From: Anita Gardner
Sent: 30 May 2018 12:45
To: Planning.Responses
Subject: FW: FG/64/18/DOC - 44 ferringham Lane
Attachments: 628-02 Layout1 (11) (1).pdf

From: Sarif Easmon-Dura [mailto:[REDACTED]]
Sent: 29 May 2018 23:50
To: Anita Gardner
Cc: Simone Cornell
Subject: Re: FG/64/18/DOC - 44 ferringham Lane

Dear Mr Easmon-Dura,
Thank you for the clarification.
Can you also confirm what screening/fencing will be provided/retained along the access driveway and the southern and western boundaries and include this on the submitted plan drawing DWG-628-11?
Regards
Anita Gardner

SCALE 1:200 @ A1
DATE 14.05.2017
DRAWN sed
DWG No. 628-02 rev. G

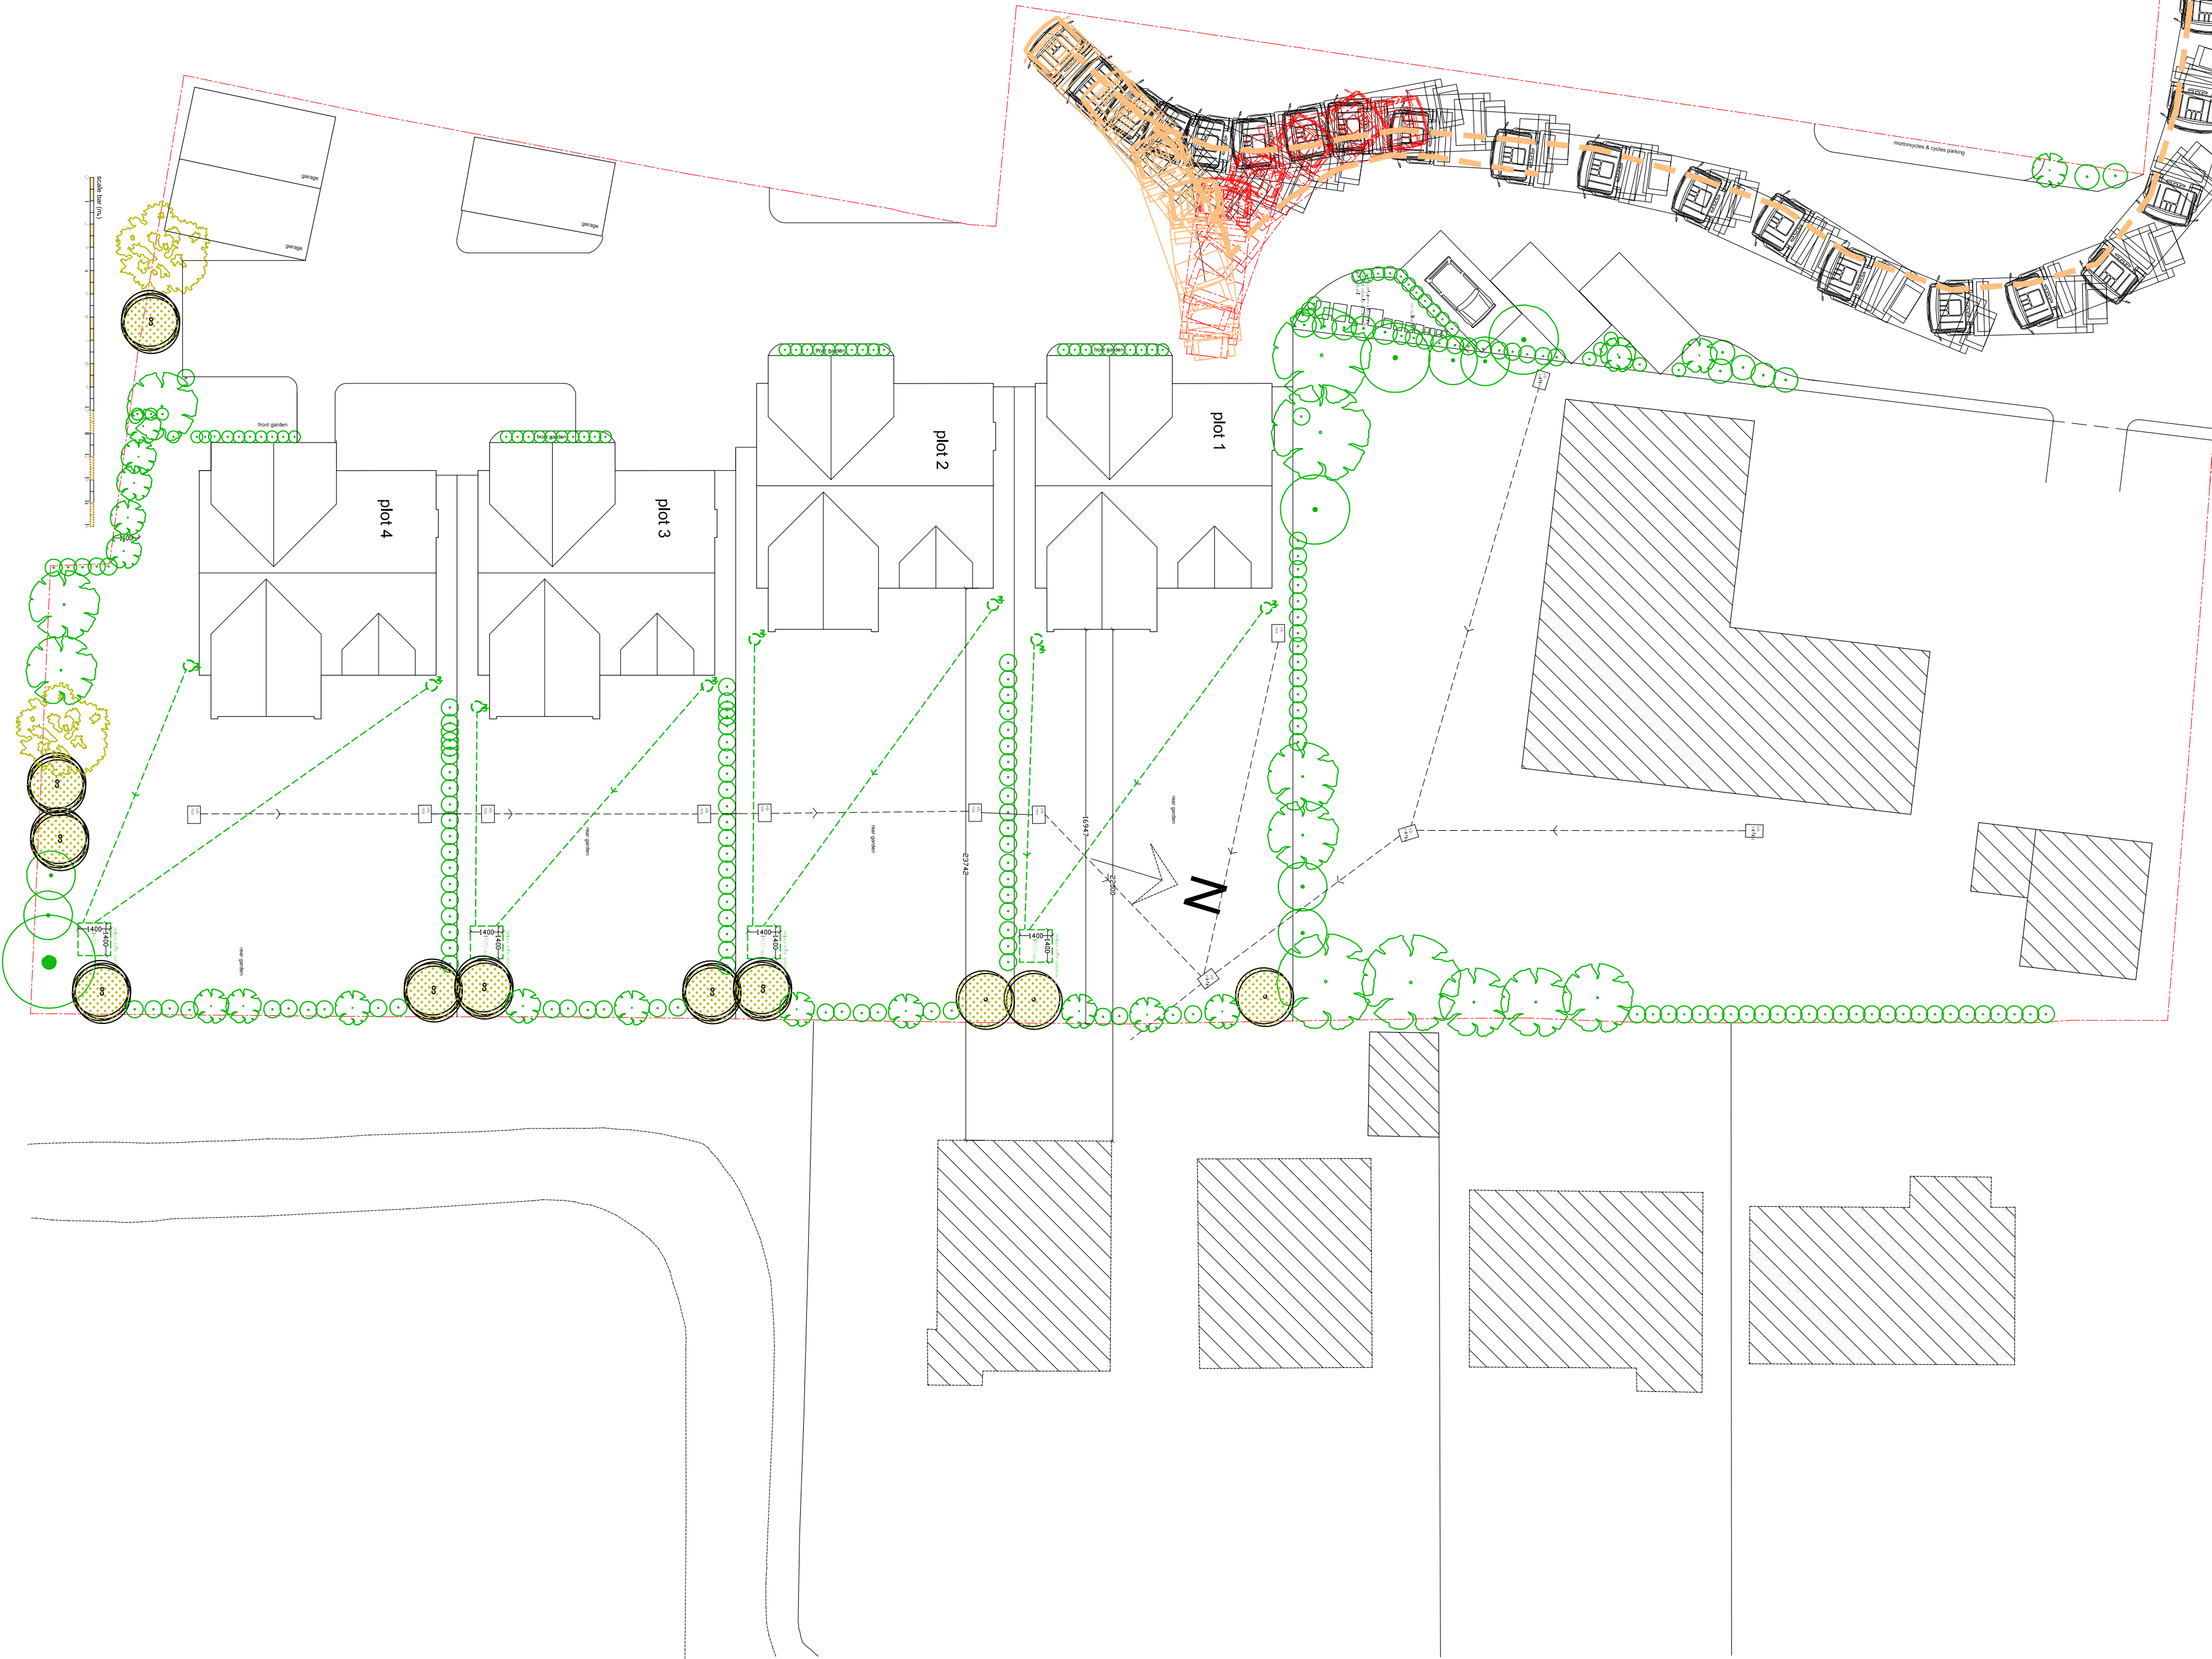
Drawing 628-11 does not make reference to the precise colour of the proposed tarmac or the colour and manufacturer of the pedestrian priority paving or permeable paving contrasting colour and these details will need to be submitted before condition 11 can be discharged.

Please accept this email to confirm that all the existing hedging to all boundaries will be retained.

As requested, I have revised drawing no 628-11 rev. B to reflect the above.

Yes, the spcs. & colour are stated - the references are on the insert at the bottom of the drawing 628-11 rev. A.

The tarmac is also shown - Black as normal tarmac.
